SUBMISSION 2: SUMMARY OF ADDITIONAL CONCERNS IN RELATION TO THE PROPOSED NORTHCONNEX TUNNEL

Application number - SSI 13_6136

This is an objection to many aspects of the proposed NorthConnex tunnel.

MOTORWAY OPERATIONS COMPLEX - SOUTHERN VENTILATION FACILITY - SECTIONS
M1-M2-5000-DR-JD-0525

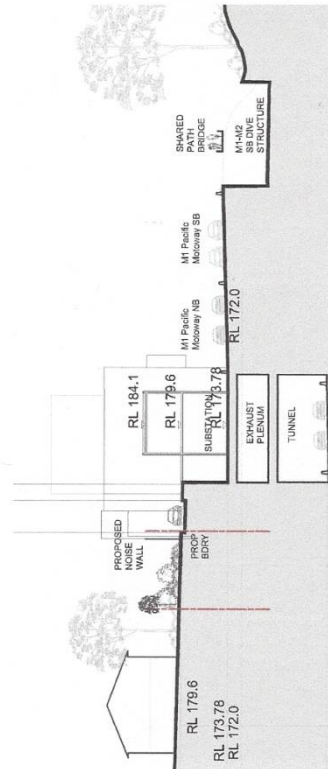
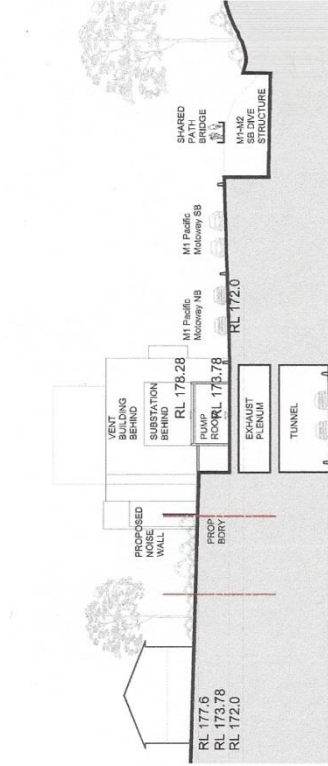
Speakers at the NorthConnex Air Quality Forum spoke of the importance of the topography in the placement of the ventilation facilities. In the NorthConnex proposal the southern ventilation facility is at the lowest point of the M2 intersection where it is surrounded on three sides by hillside cuttings. In this location the “discharge point” will barely be above the adjacent high ground.

Much is made of the intention to discharge the polluted air through the stack at 13 – 19m/s. Given that the stack is only 15m above Pennant Hills Road, a simple calculation indicates that the particles will be ejected to a height of between 23m and 33m above Pennant Hills Road. That will only be sufficient for them to be dispersed by prevailing winds IF there is wind and it is strong enough. For instance, the weather history graph showing the wind speed and direction at West Pennant Hills measured on the 24th August 2014 indicated that there was no wind until 9am and what wind there was, came from the west. Wind speeds of less than 2m/sec (ie about 8km/hour) are not considered sufficient to disperse pollution from the stack. Only a very few gusts on this day were in excess of 8km/hour.

That the Government ensures that the southbound ventilation facility ie the Stack, be located at the south-west corner, on the RMS owned land, at the edge of the Pennant Hills Golf course. In this location, the southbound tunnel can be efficiently, effectively and economically ventilated.

The impact of the stack plumes on the surrounding residential areas must be modelled using its current proposed position and height and also modelled with the stack positioned on the golf course side of Pennant Hills Road, where it is topographically higher. This would allow an objective, impartial, scientifically based assessment to be made of the most effective location for the stack.
